**Consultation Response from KC,
Lead Local Flood Authority**

2022/91735 Land off, Hermitage Park, Lepton, Huddersfield, HD8 0JU

Outline application for erection of residential development

Date Responded: 11th July 2022

Drawing Title.
EXISTING DRAINAGE

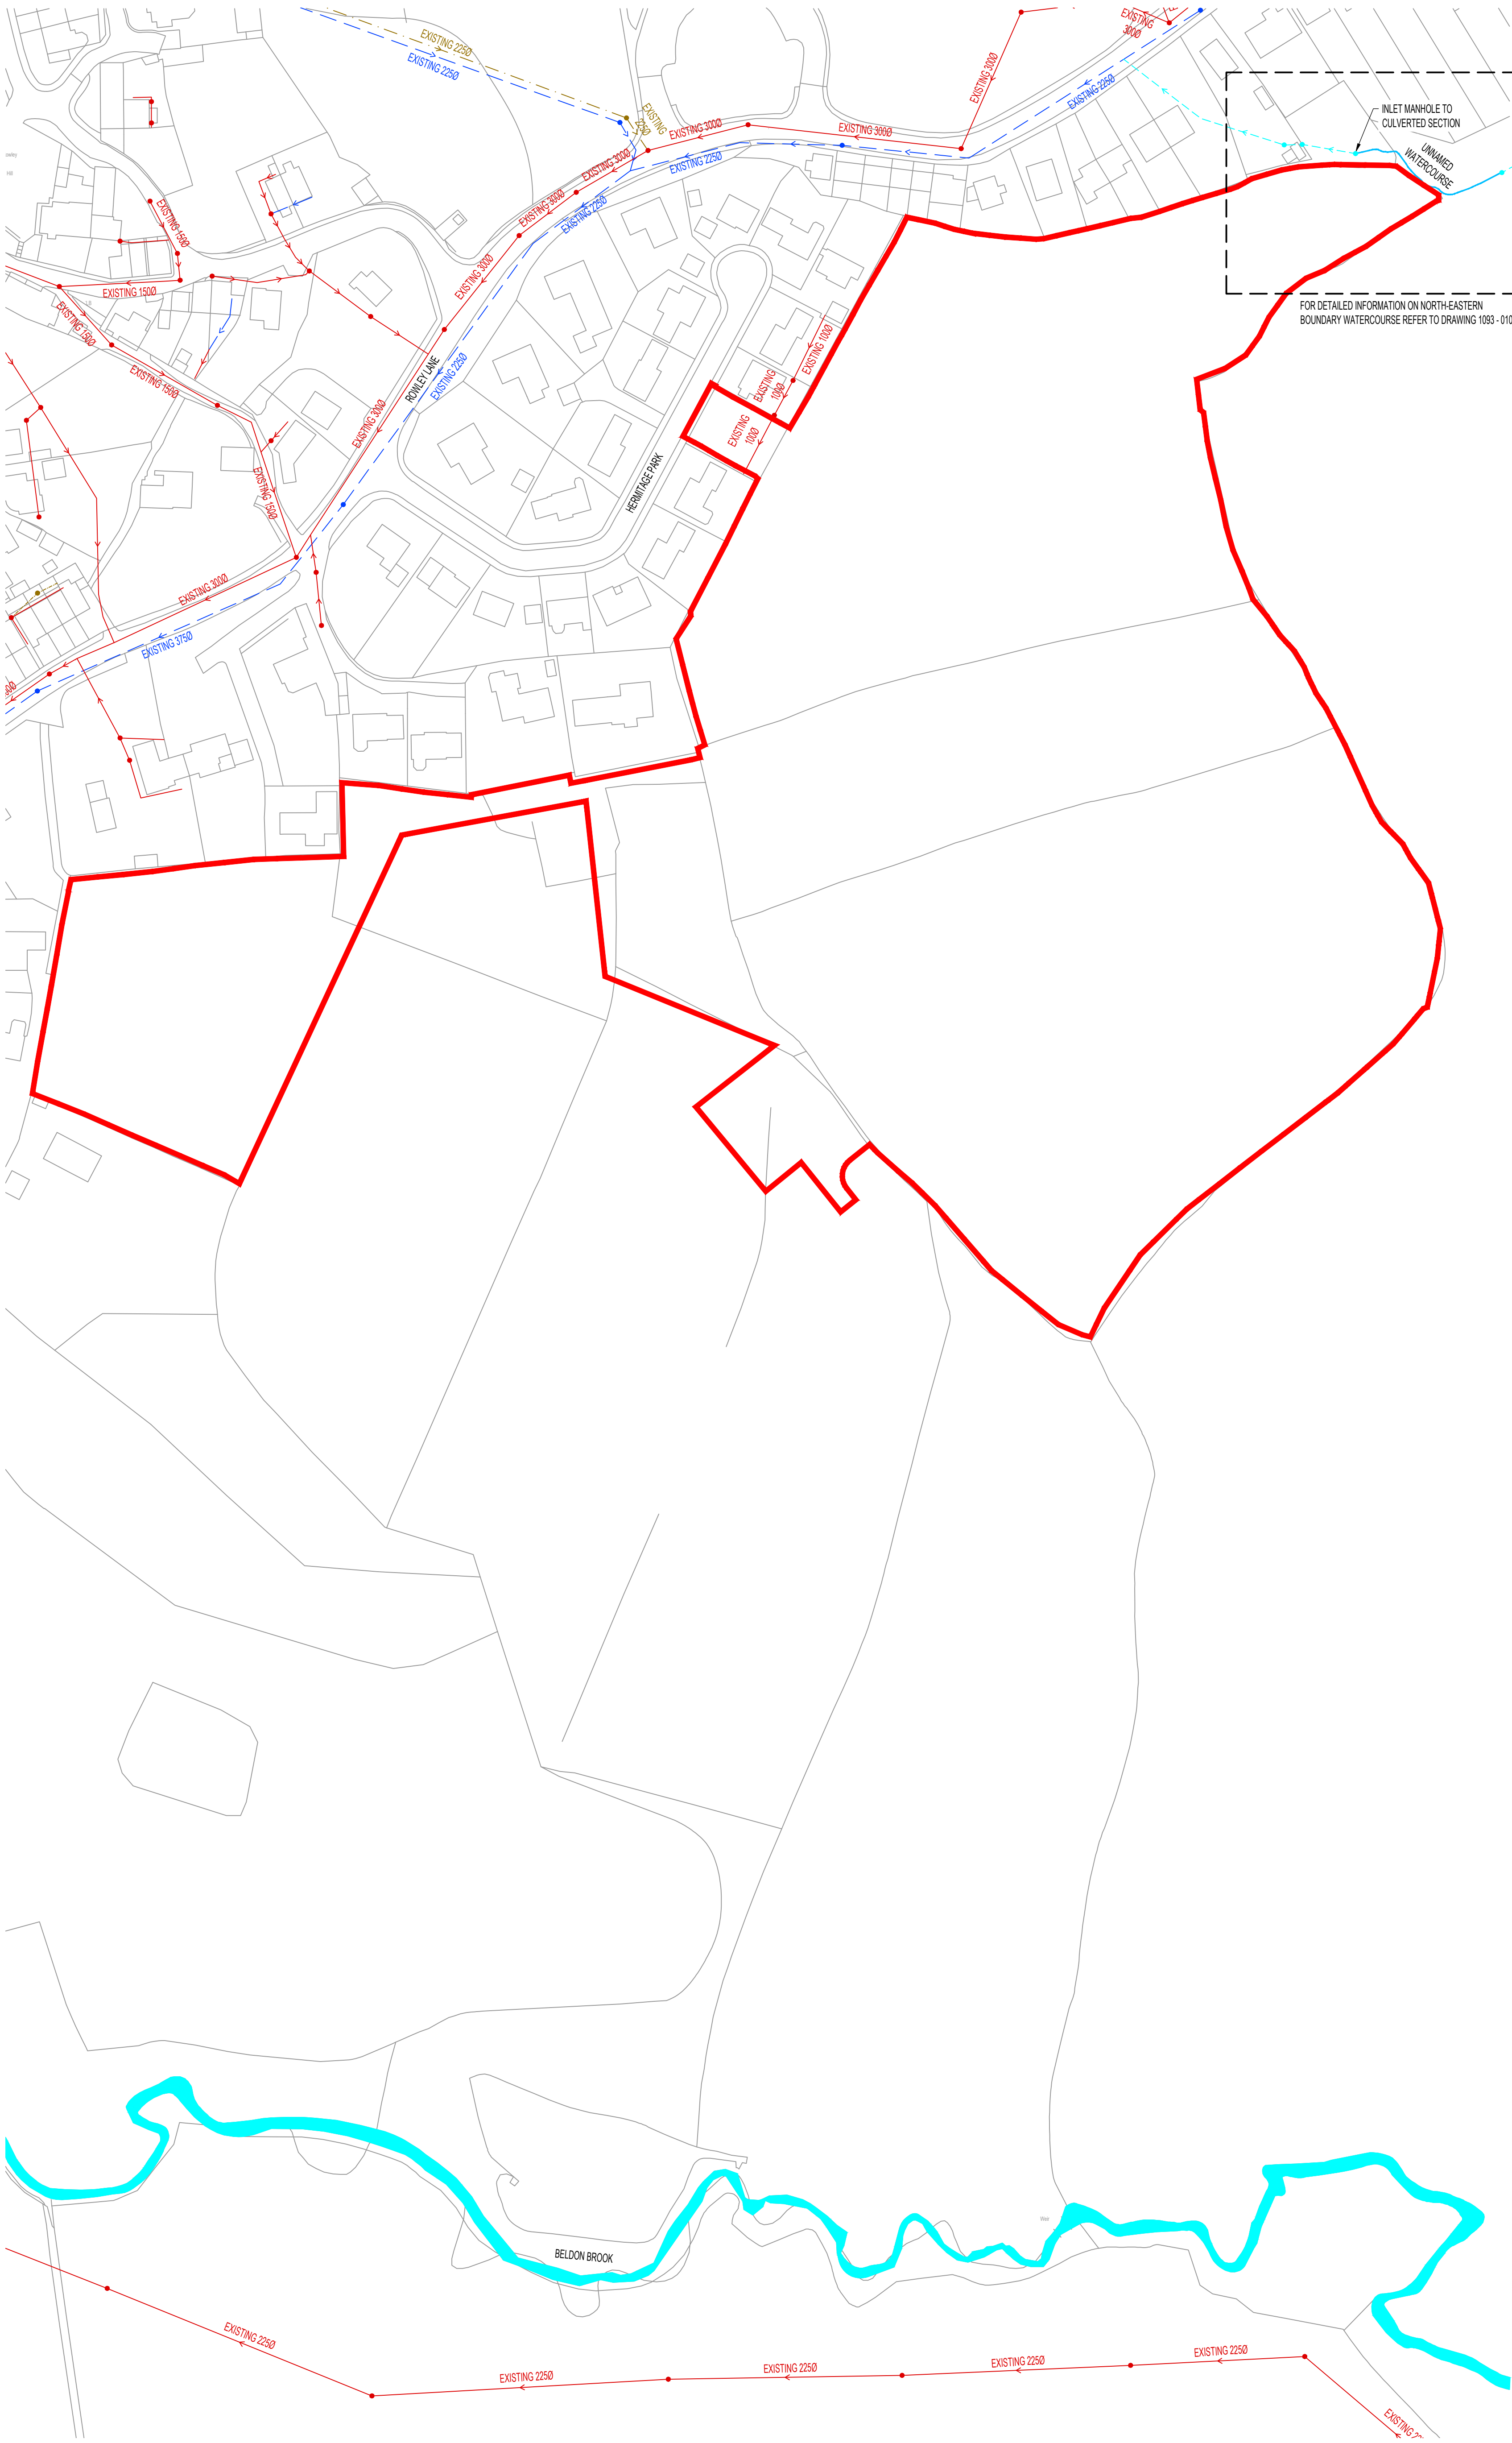
Watercourse on North East Boundary

A detailed level survey and total blockage scenario in the area around this watercourse should be included in a flood risk assessment to show where water will flow overland in such an event, where it will go pre- and post-development. Weir points should be clearly identified.

The current Flood Risk Assessment suggests there is risk to site and a swale should be included to get water safely to Beldon Brook. This will require planning for this site and the wider masterplan. With layout being assessed for this application, a detailed design is required that should then be reflected on all drainage, engineering, landscaping, and constructions drawings.

An assessment of the current trash screen is also required to see if it meets current requirements given risk is to increase by building properties in the area.

A land drainage feature located within the site has been picked up during the consultation period. This needs investigating in the FRA as a possibility of a small on site watercourse. Please contact the LLFA (Paul Farndale) for more details 01484 221000
